# **BUILDING CODE OF AUSTRALIA 2022 CAPABILITY REPORT FOR DA SUBMISSION**

<b>CLIENT:</b>	<b>NSW HOUSING CORPORATION PTY LTD</b>
<b>PROJECT NAME:</b>	<b>MIXED USE DEVELOPMENT</b>
<b>PROJECT ADDRESS:</b>	<b>2-4 BURLEIGH STREET &amp; 20-24 RAILWAY PARADE, BURWOOD NSW 2134</b>
<b>DATE:</b>	<b>30 JANUARY 2025</b>
<b>PROJECT NO:</b>	<b>230266</b>

AllCert Pty Ltd has been engaged by NSW Housing Corporation Pty Ltd to provide a Building Code of Australia (BCA) 2022 compliance report for the proposed mixed-use development located at 2-4 Burleigh Street and 20-24 Railway Parade, Burwood NSW 2134.

1 BASEMENT LEVEL 3 - RESIDENTIAL PARKING
1:200

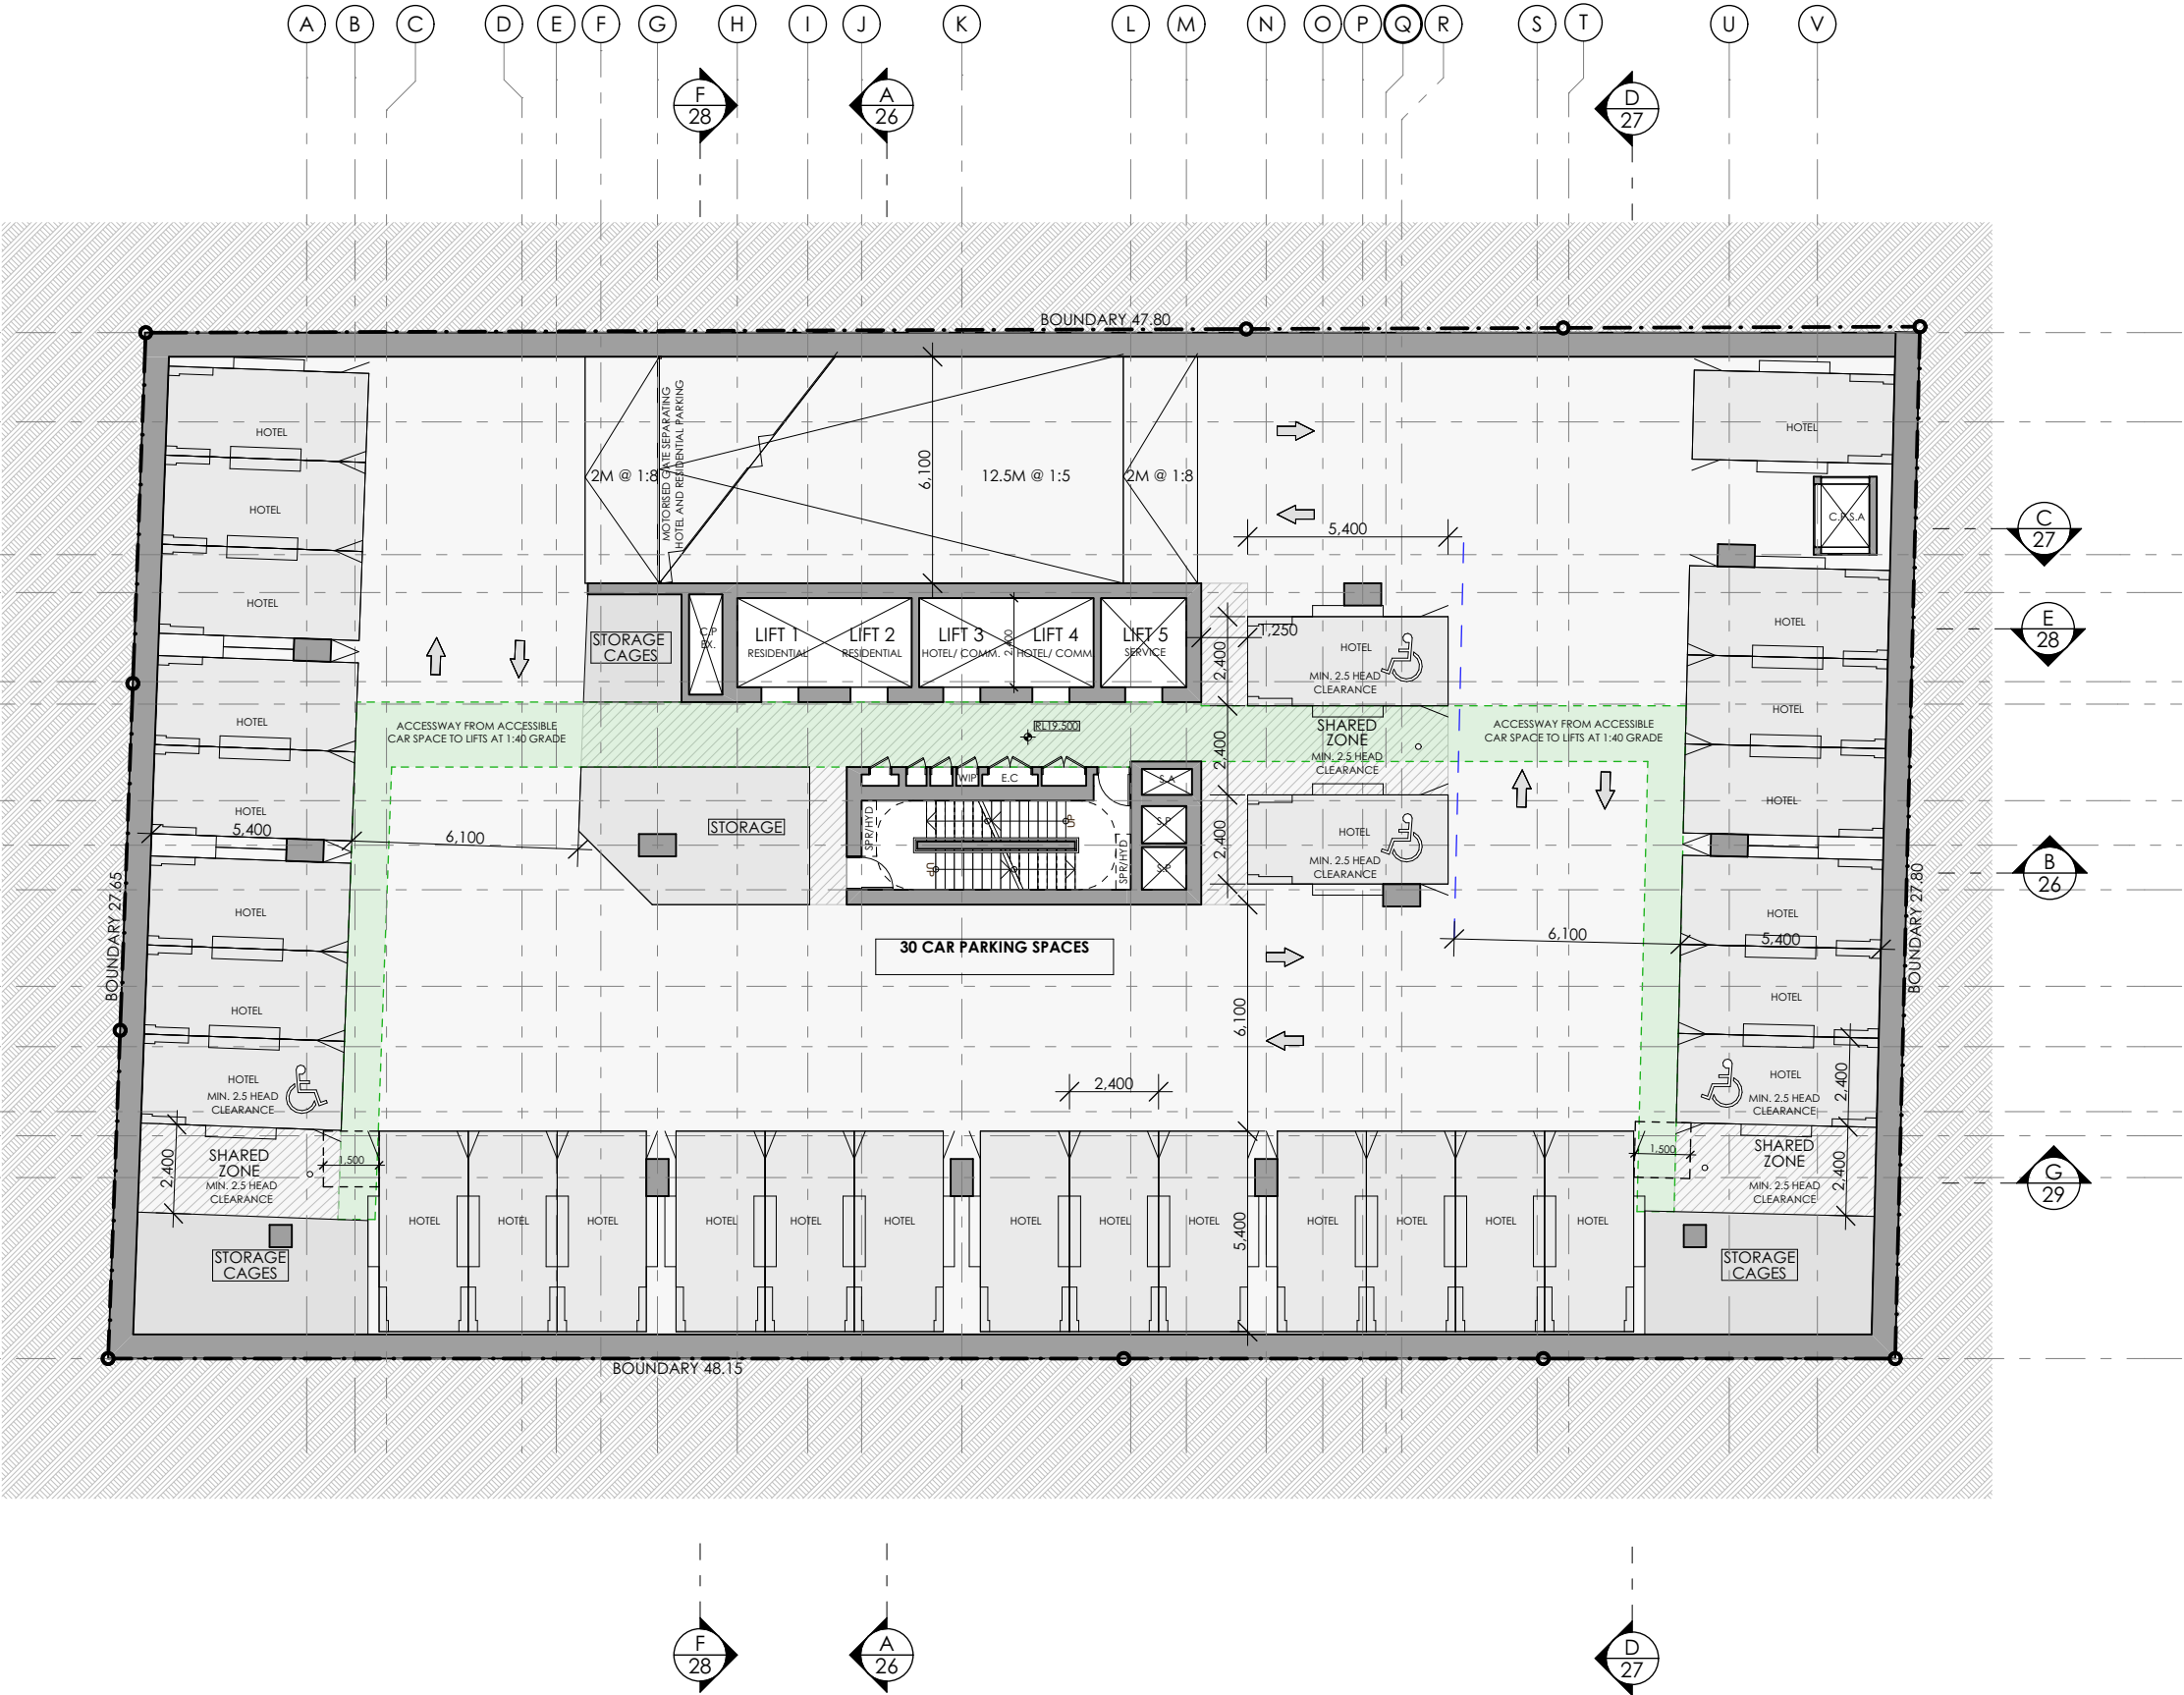
<p>5.</p>	<p>D2D5</p>	<p><b>Basement Level 3:</b> The travel distance to the point of choice exceeds 20m for each corner of the basement. A performance solution is required to address this non-compliance.</p>	<p>A performance solution is to be provided at the Construction Certificate Stage.</p>
<p>6.</p>	<p>D2D5</p>	<p><b>Basement Level 2:</b> The travel distance to the point of choice exceeds 20m for each corner of the basement. A performance solution is required to address this non-compliance.</p>	<p>A performance solution is to be provided at the Construction Certificate Stage.</p>

DRAWING TITLE:
**LEVEL 37 FLOOR PLAN- HOTEL
FACILITIES**

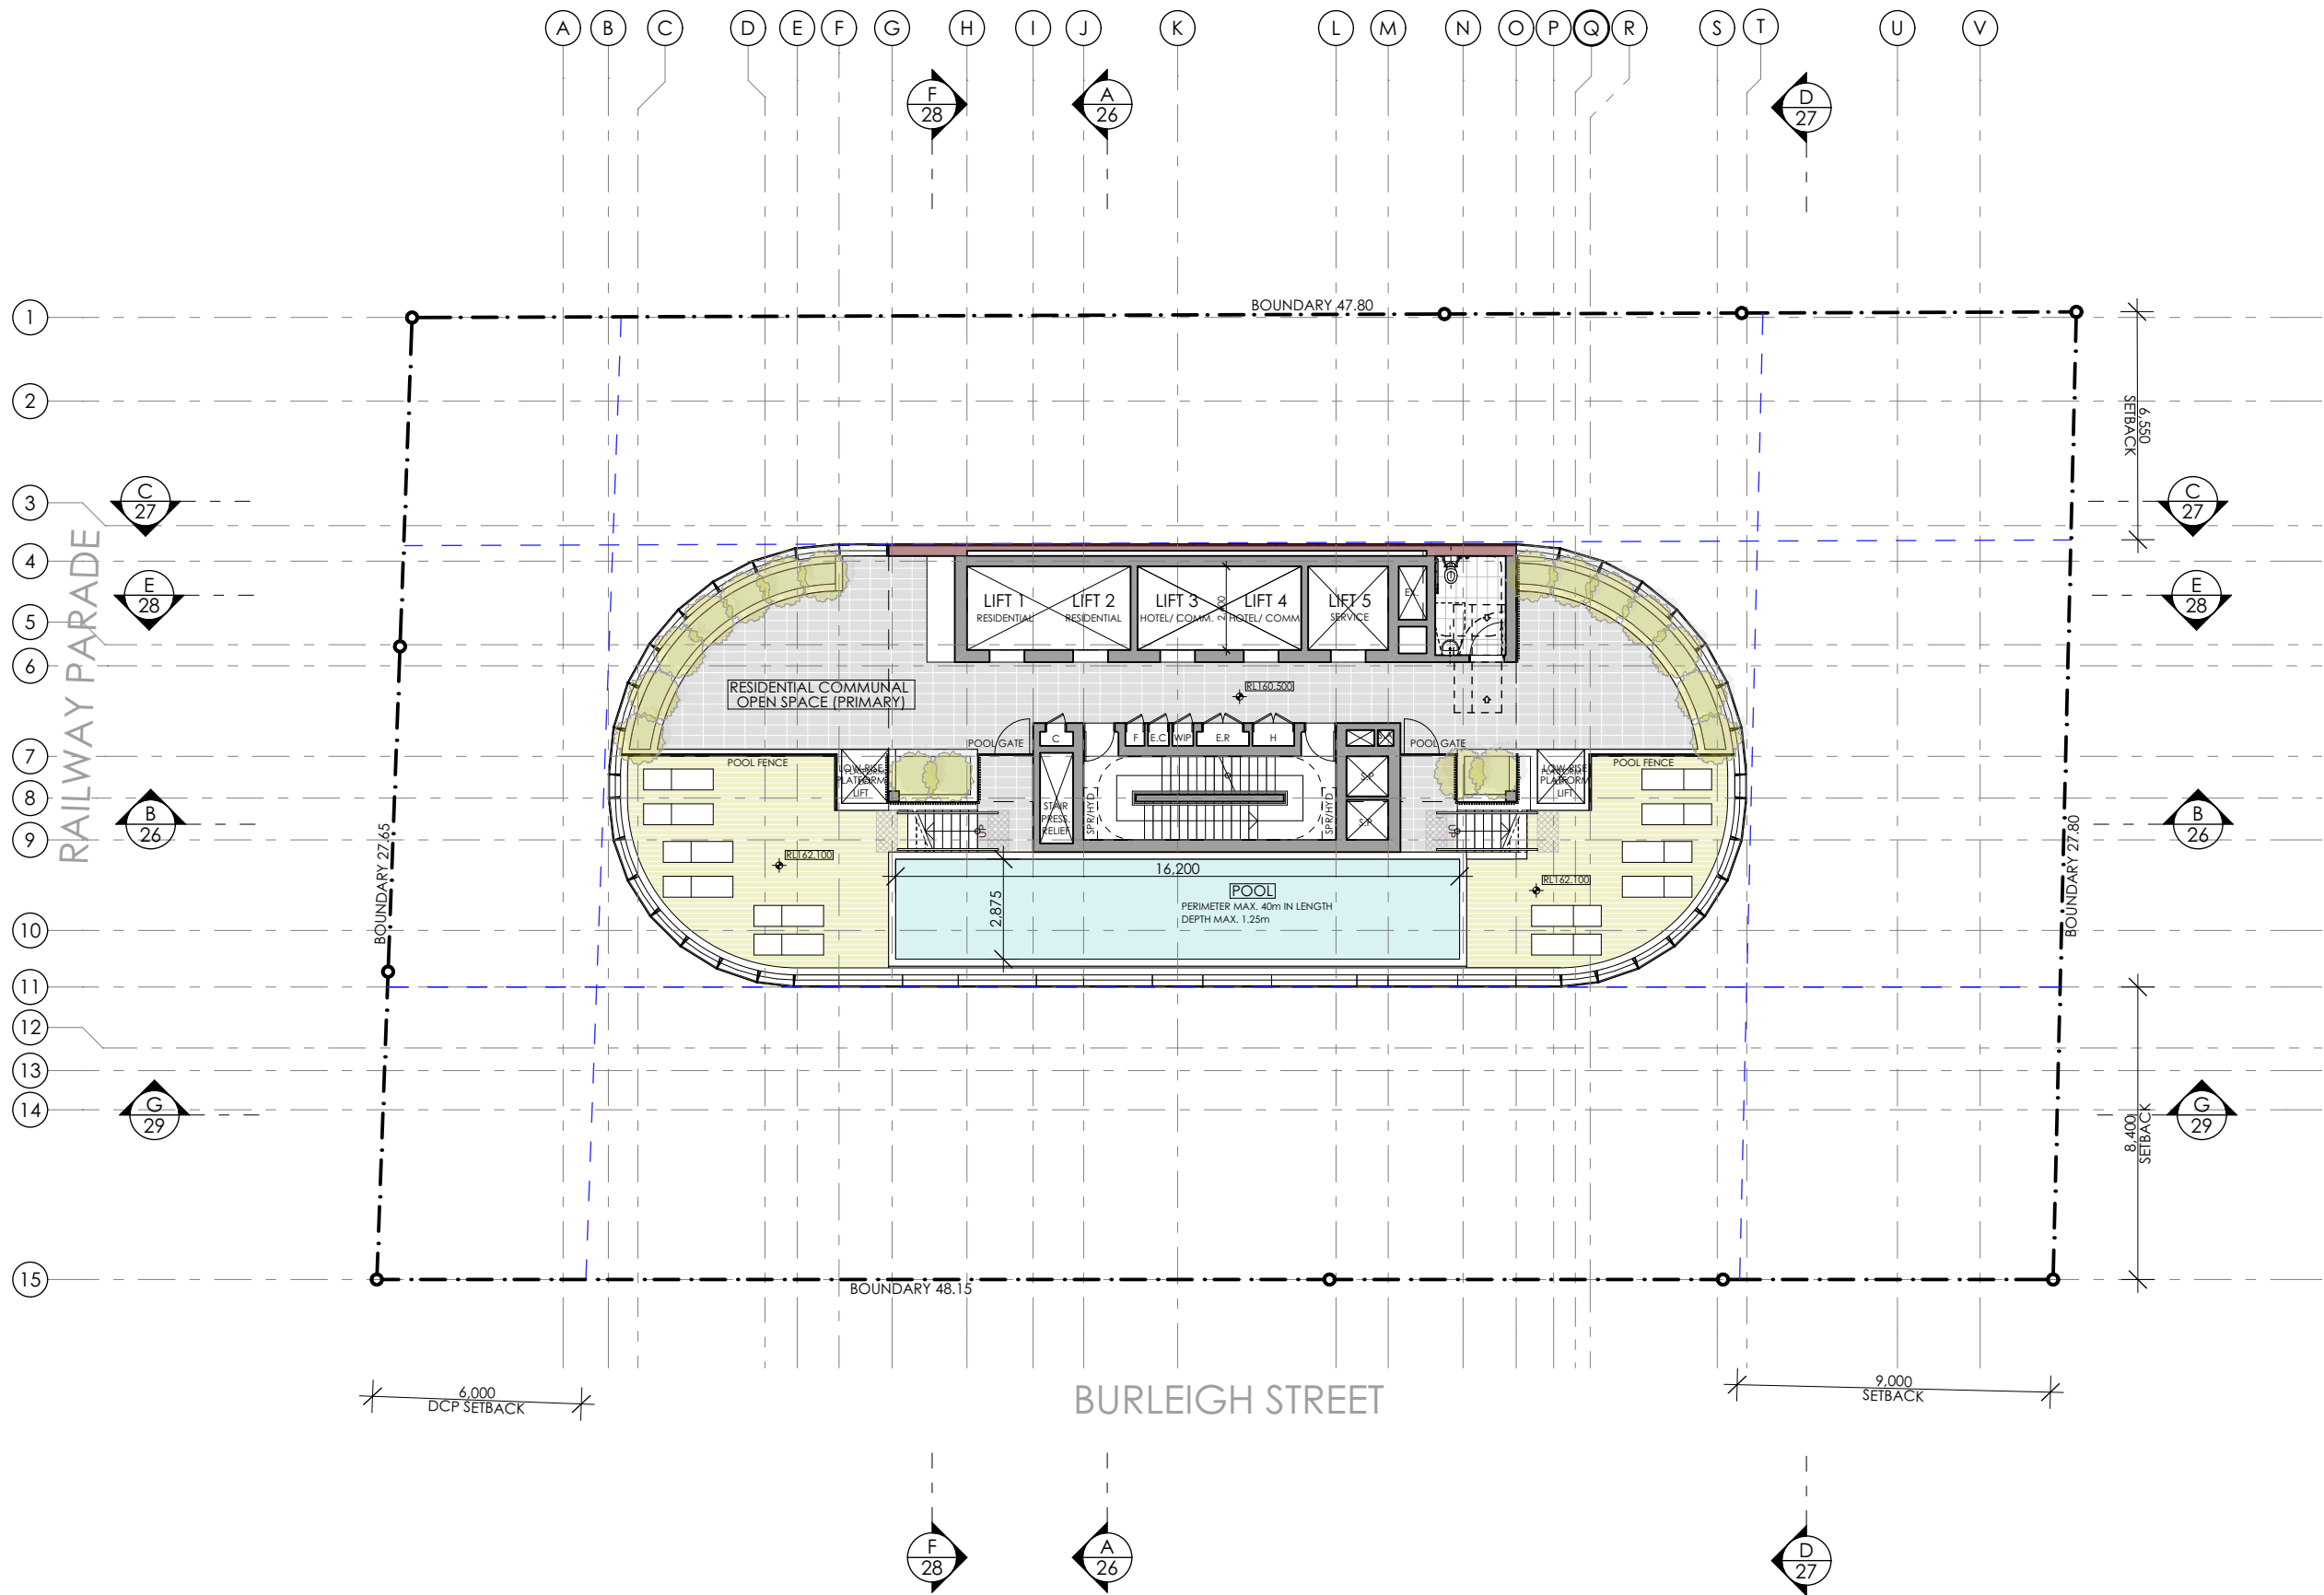
<p>3.</p>	<p>D2D8</p>	<p>Level 37 - The maximum capacity of the storey, based on the deemed-to-satisfy provisions is 200 persons.</p> <p>The number of persons accommodated in accordance with D2D18 is 212 persons.</p> 	<p>The number of persons accommodated is only an assumption at this stage. Clarification of the number of people accommodated is to be confirmed by the architect. A performance solution by the fire safety engineer may be provided to justify the reduced egress width.</p>
<p>4.</p>	<p>D2D8</p>	<p>An unobstructed width of 1m is required on the path of travel to an exit from the hotel kitchen on Level 36.</p> 	<p>Minor design change required at the CC stage.</p>
